Our Ref: BE/92/21/DOC

Part 5 of the Town & Country Planning (Development Management Procedure) Order 2015
Approval of details reserved by condition imposed under ref. BE/135/18/PL relating to
Condition No. 15 (full permission) regarding the submission of As-Built Drawings and a
Completion Report prepared by an independent engineer

Land at Salt Box, West of Shripney Road, Bognor Regis

Arun District Council have decided to **REFUSE details reserved by this condition**

CLIENT			
LANDLINK ESTATES			
PROJECT			
SALTBOX BOGNOR REGIS			
TITLE			
DRAINAGE DETAILS SHEET 1			
HYDROCK PROJECT NO. C-13319-C		SCALE @ A1 AS SHOWN	
STATUS DESCRIPTION AS BUILT ISSUE		STATUS A	REVISION C04
DRAWING NO. (PROJECT CODE-ORIGINATOR-ZONE-LEVEL-TYPE-ROLE-NUMBER) SAL-HYD-00-ZZ-DR-C-7100

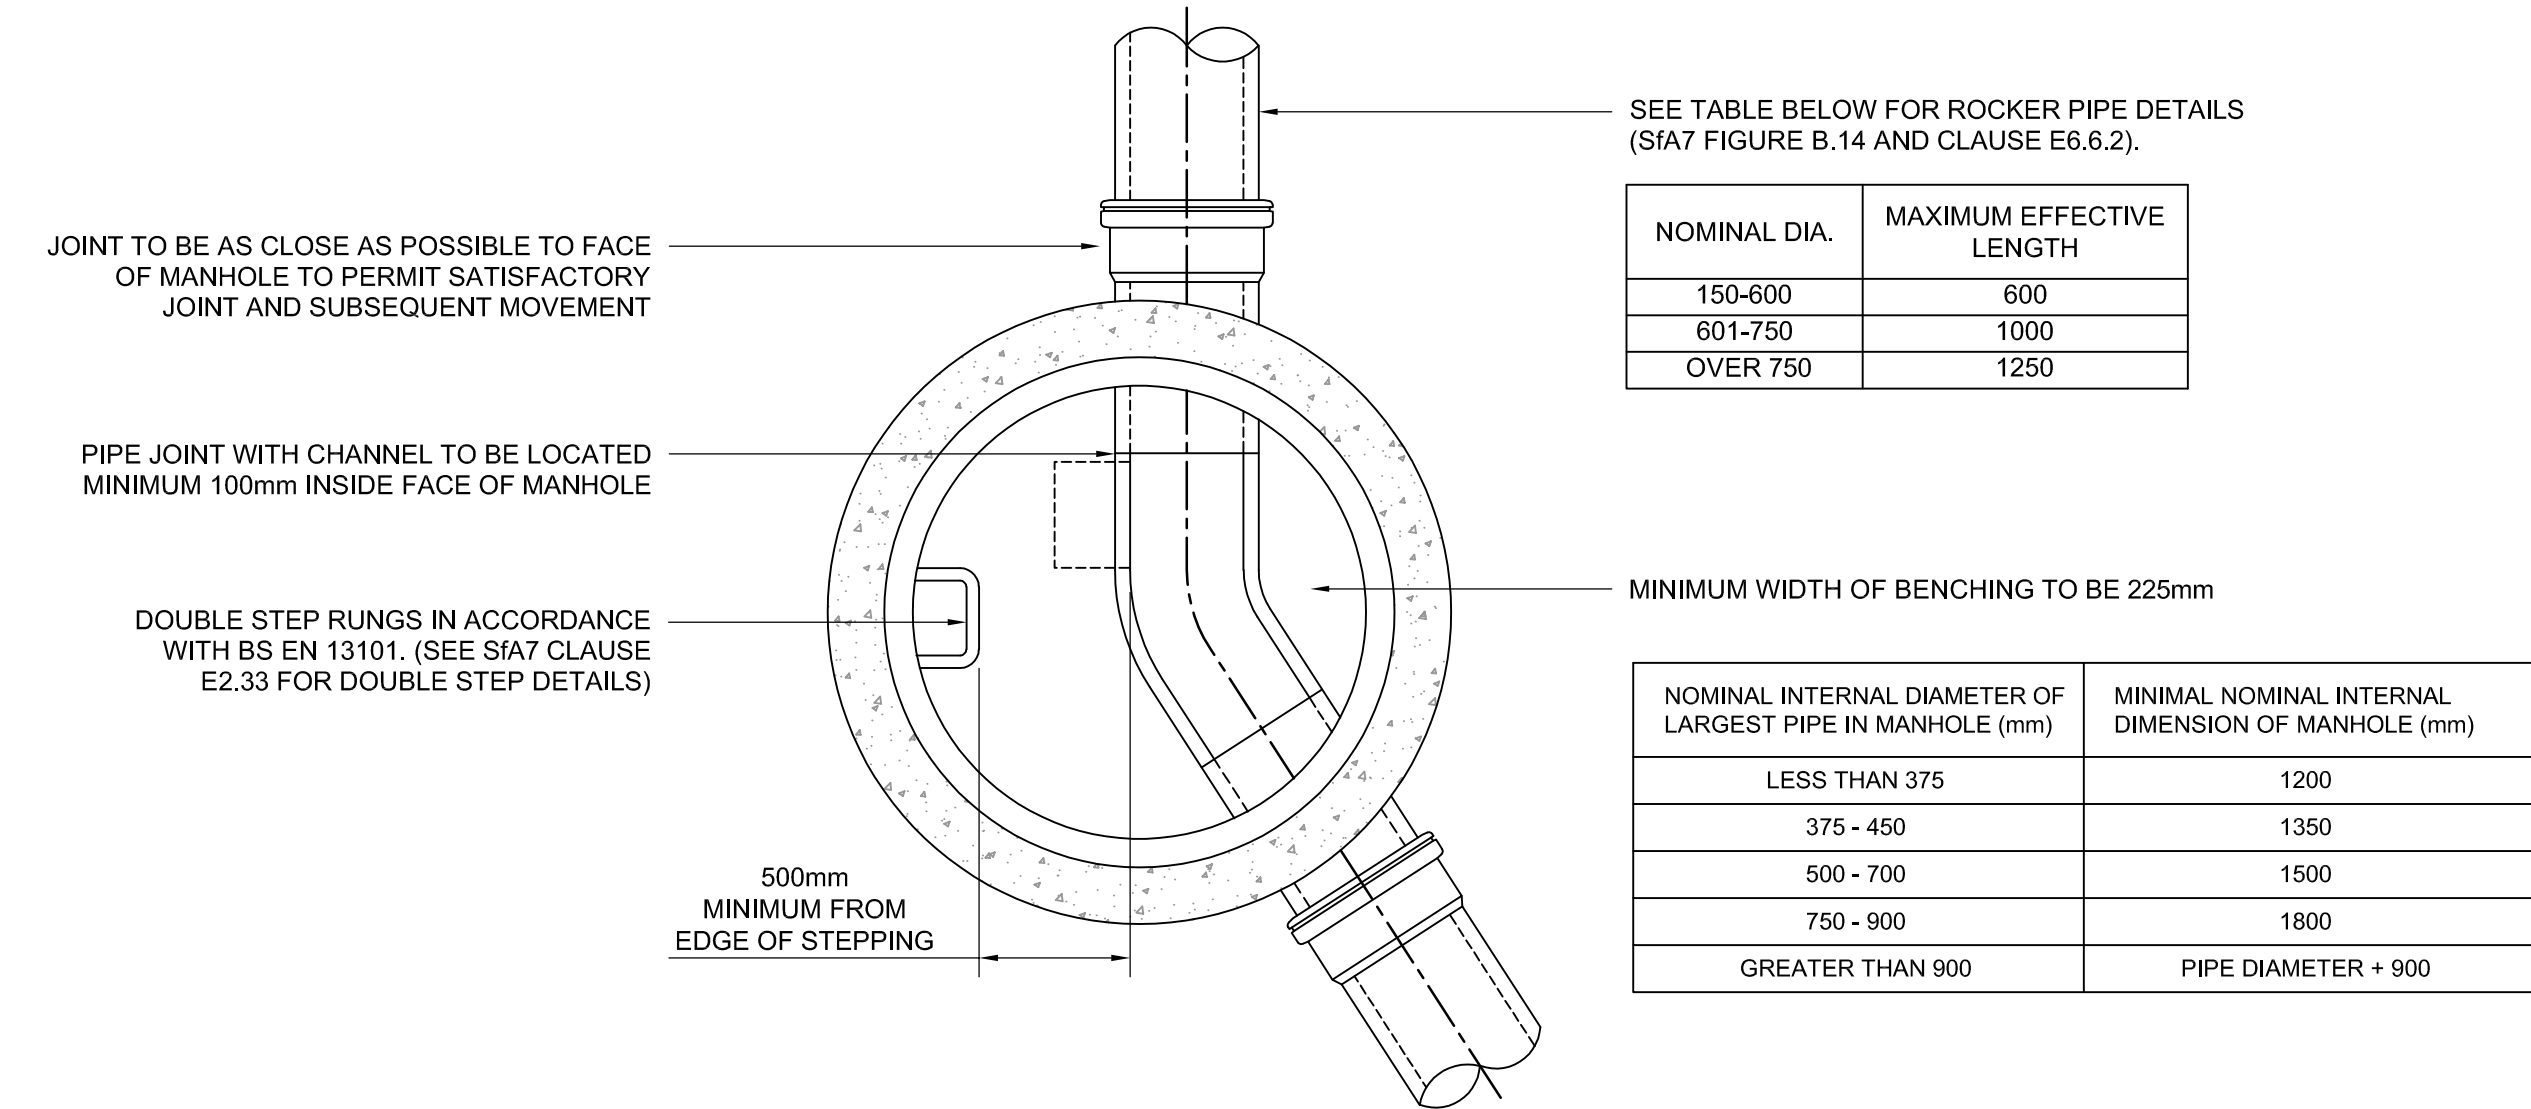
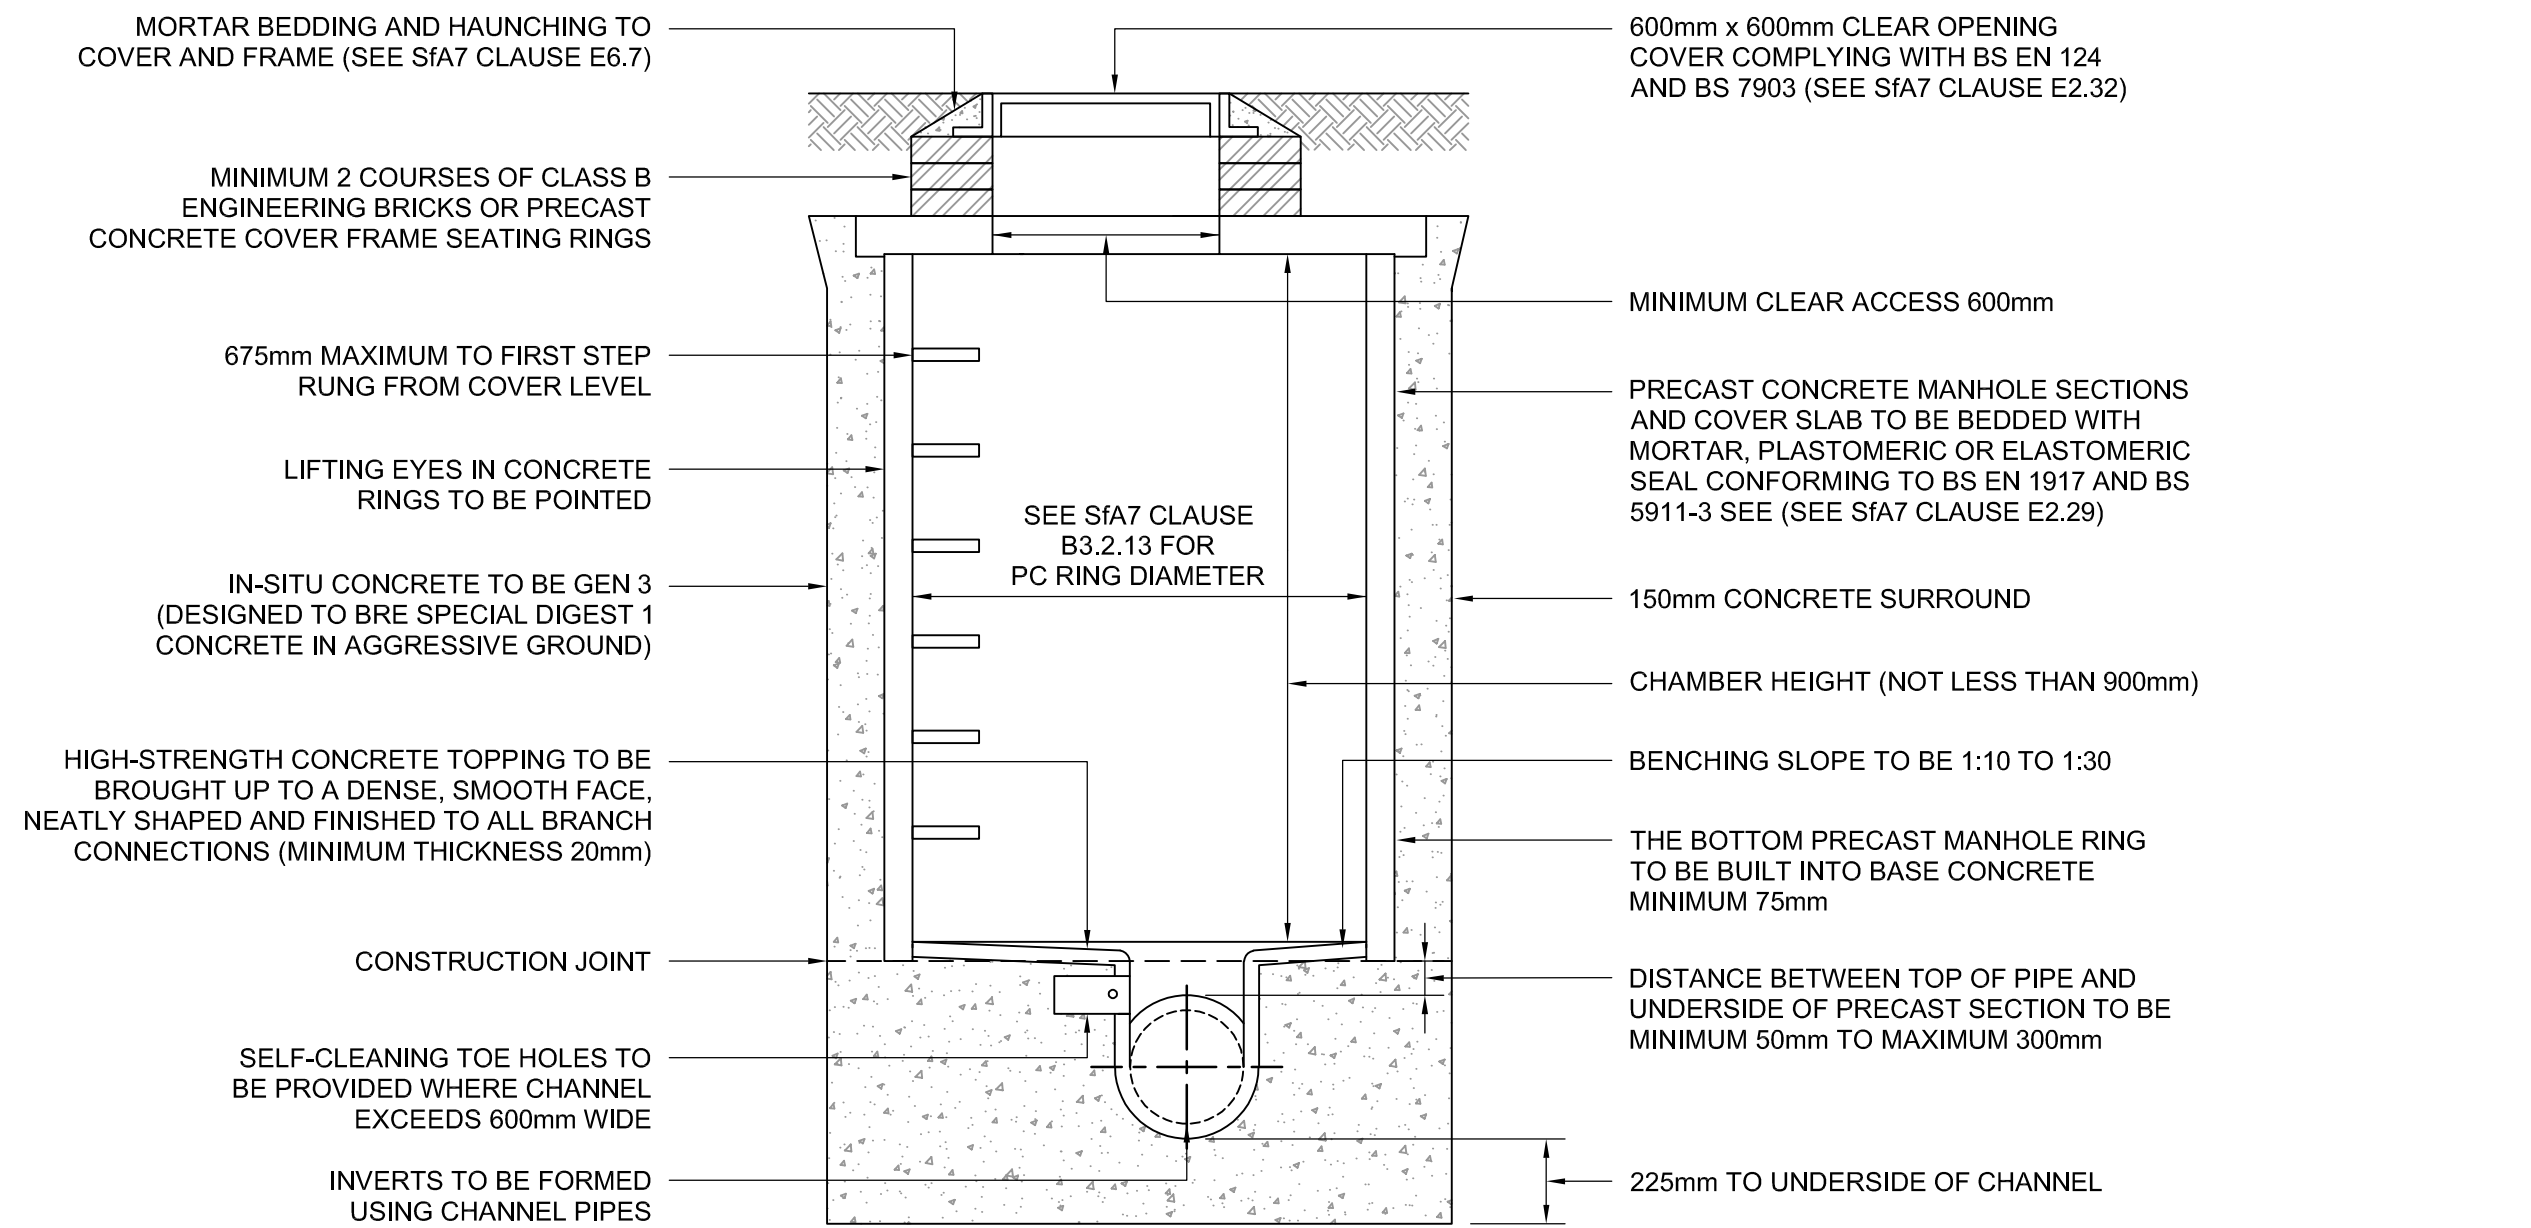
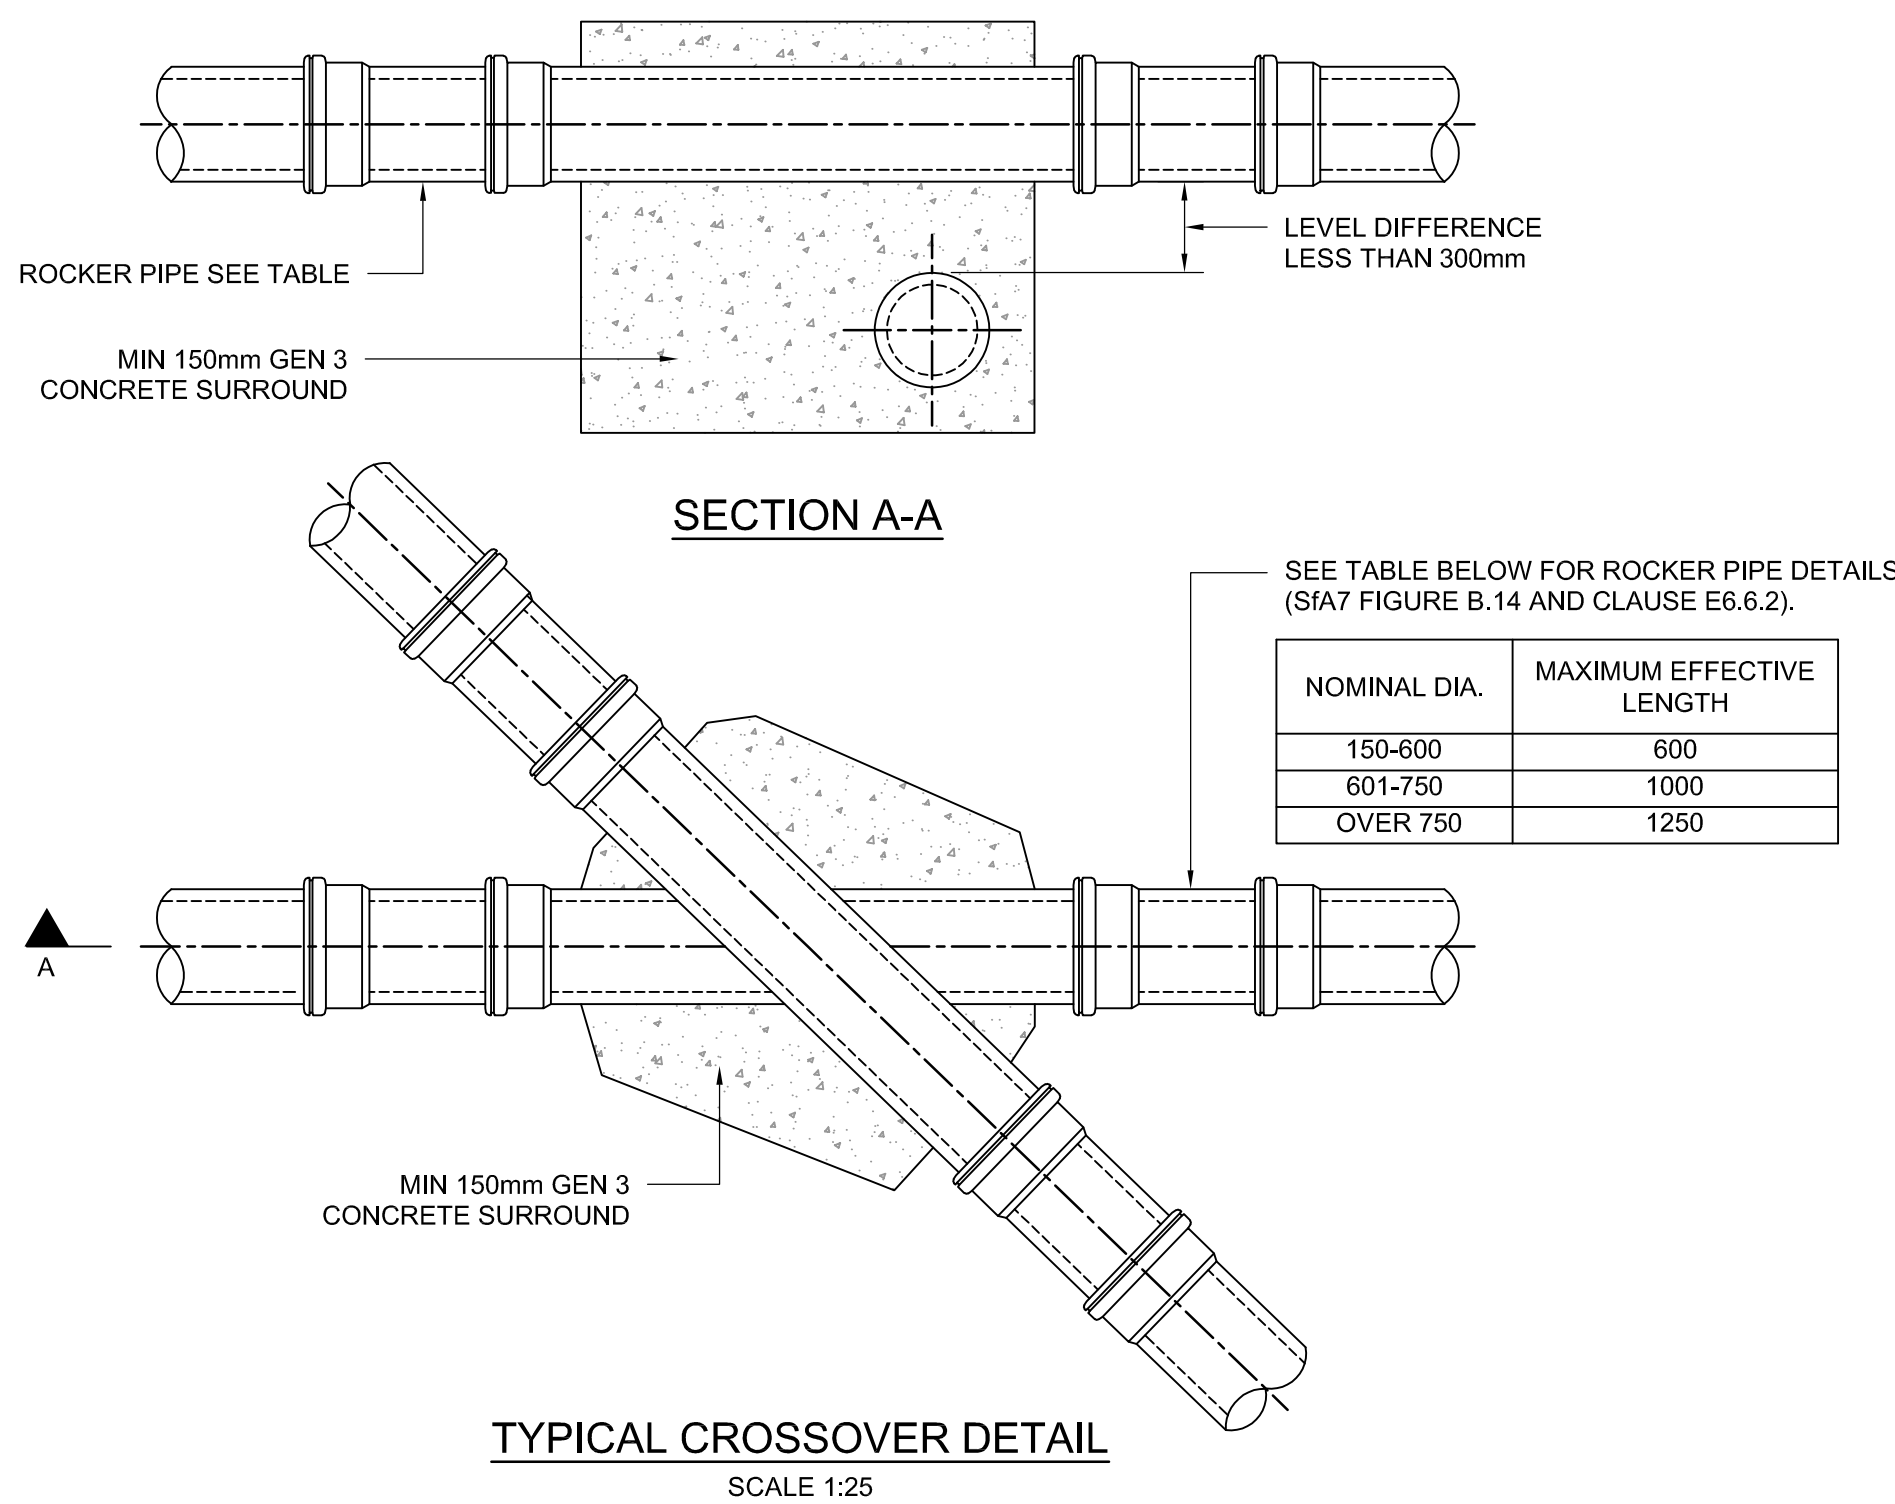
It is evident that substantial changes have been made to the drainage since the approval. A review of these changes has been completed. Levels at some manholes are considerably different between the approved design and as built drawings, the difference in levels is in excess of 50mm in some areas. It appears that at one location an outgoing invert is significantly above the incoming invert to the chamber, and in others downstream inverts are higher than the invert levels of upstream attenuation crates.
